Proposed single storey rear extension.
3 Granary Way Littlehampton

Thank you for your internet comments made on 30th April 2019 which has been recorded as **'no objection'** with the comments as follows:

Date:	Scale:	Paper size:	Dwg No:
Mar. 2019	As shown	A3	AR-139-04

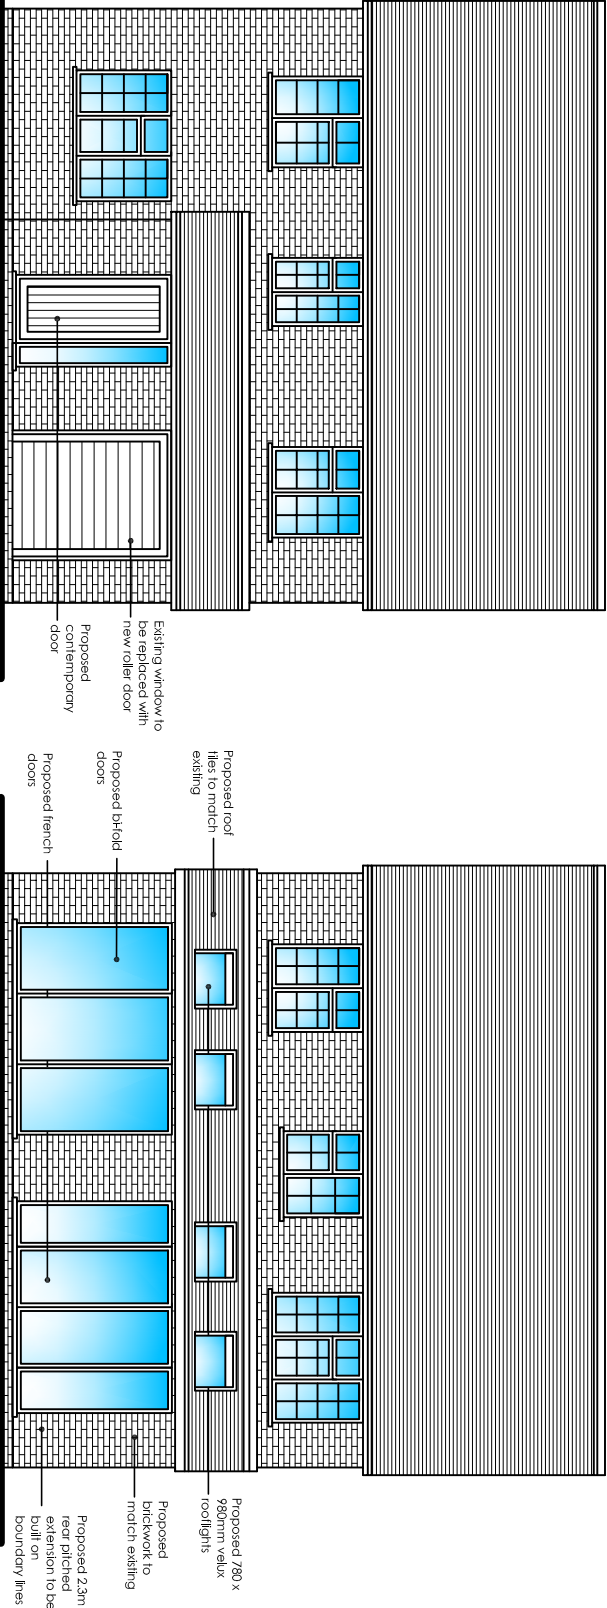
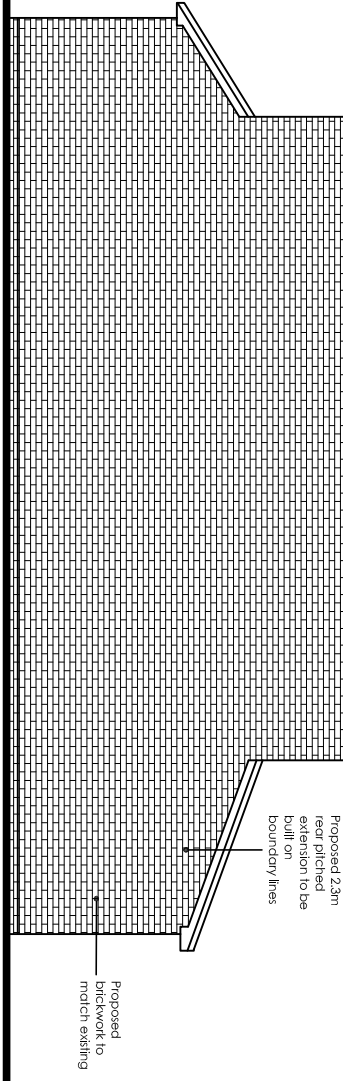
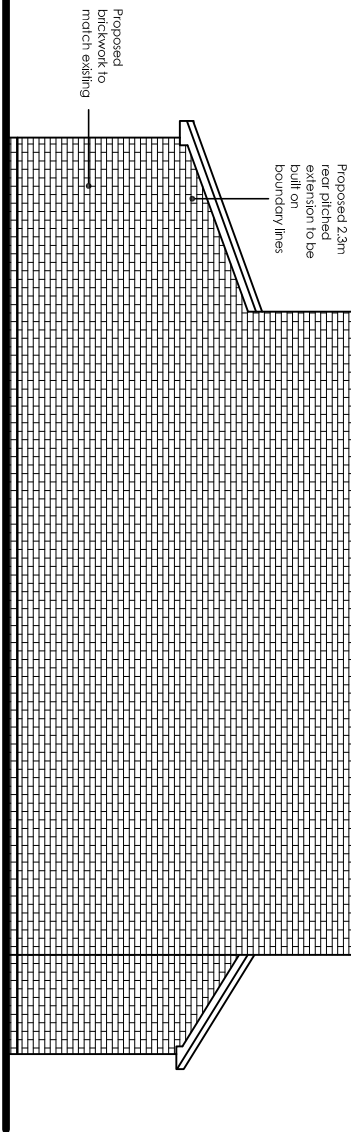
The Town Council's Planning and Transportation Committee considered this matter at its meeting held on Monday 29th April 2019 and had no objection to the application. The Committee also wished to draw attention to the proposed installation of a roller shutter at the front of the property and questioned why it was not specified in the description of the application.
